Gatwick Airport Northern Runway Project

Statement of Common Ground Between Gatwick Airport Limited and Environment Agency – Tracked Version

Application Document Ref: 10.1.12

Figure 4.1: Schematic of Museum Field FCA

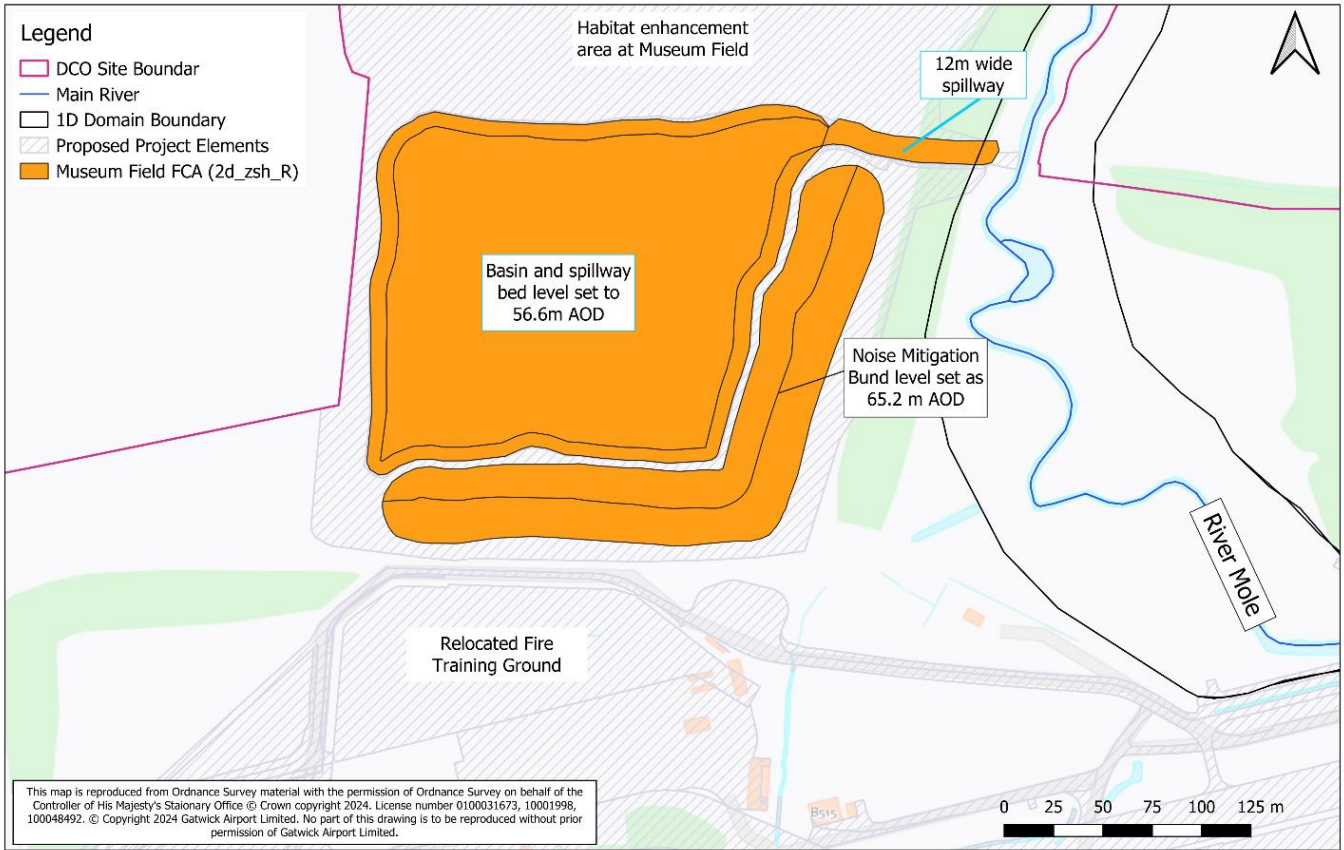
2.8.3.1	Museum field: retaining existing mature habitat where it is compatible with the function of flood compensation area	There are existing mature trees situated within in the Museum Field, which were discussed in a previous joint consultation meeting whether these might be retained and could be assessed for compatibility with the function of that flood compensation feature. The landscaping plans refers to a clear space with new grassland being created within the flood compensation area and note the landscaping design approach which will test the suitability of existing habitat features for incorporation and retention. However, it remains unclear about the fate of these trees within the Museum field flood compensation area, and therefore request clarification. The approach is welcome with established river corridor habitat structures and commitments to protect these sensitive receptors from light pollution at all phases of development.	The flood compensation area has been sized and designed to ensure that the majority of trees that surround the area are retained. The only exception will be a small section on the eastern boundary to facilitate connection to the River Mole. An Arboriculture Impact Assessment and Tree Protection Plan are being produced and will be shared once available.		Agreed
